11 March 2020

**FG/6/20/PL - DEVELOPMENT OF ANIMAL RESCUE CENTRE
HANGLETON FARM LIVERY STABLES, WADARS ANIMAL RESCUE
CENTRE, HANGLETON LANE, FERRING BN12 6PP**

On behalf of our client, Mr Geoffrey Fox of Reynard's Nursery, Hangleton Lane, Ferring BN12 6PP, we make the following objections in respect of this planning application.

CANINE ISOLATION
Floor Plan 1:100

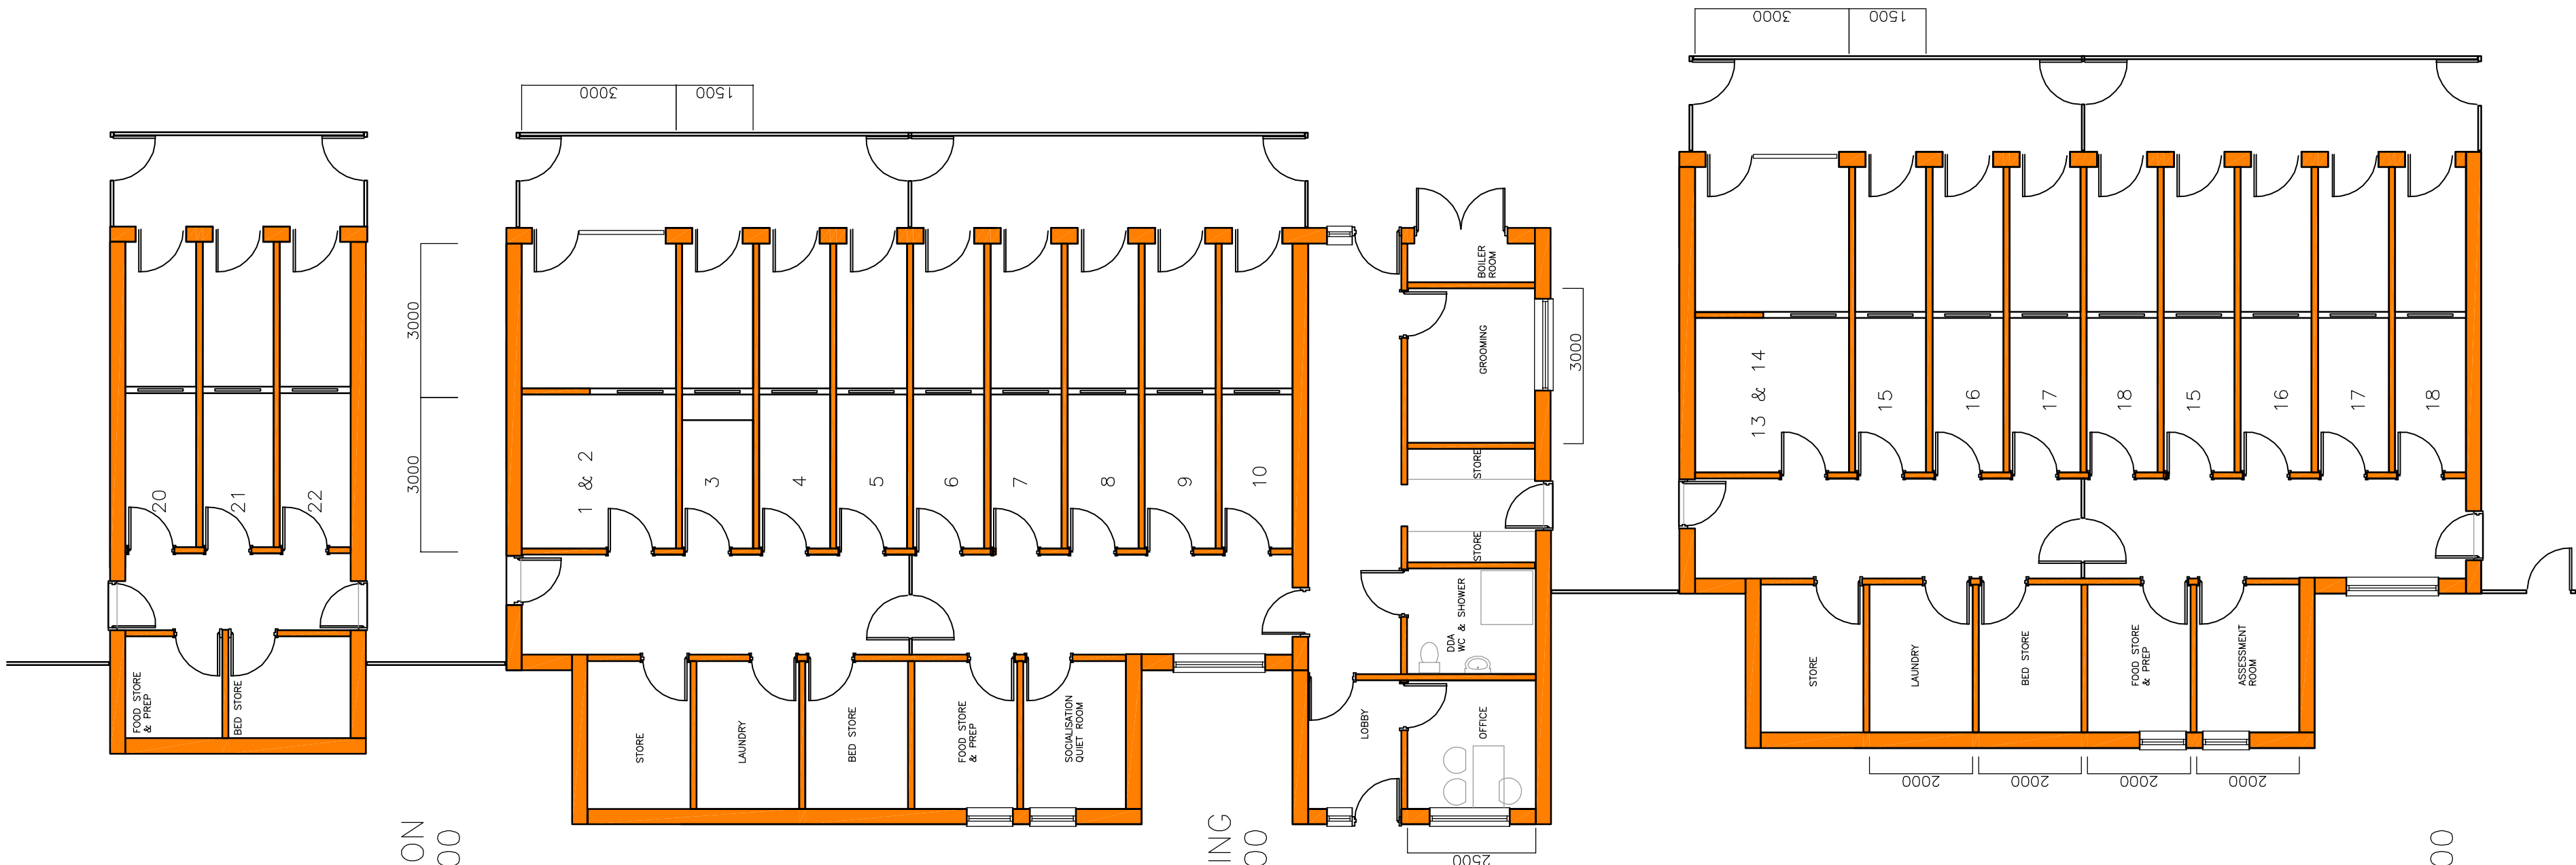
The proposal includes kennels with dogs being kept in three buildings and in outside runs. The floor plan shows 23 numbered kennels, although the application does not appear to state the maximum number of dogs which could be accommodated.

These requirements do not appear to have been met. Further information about noise impact and any mitigation possible should be submitted, in accordance with local plan policies QE DM1 and EMP DM1, before a decision is made so that these matters can be considered fully and properly.

- control over the maximum number of dogs
- noise level limits
- management and control measures
- measures to reduce noise emanating inside and outside the building
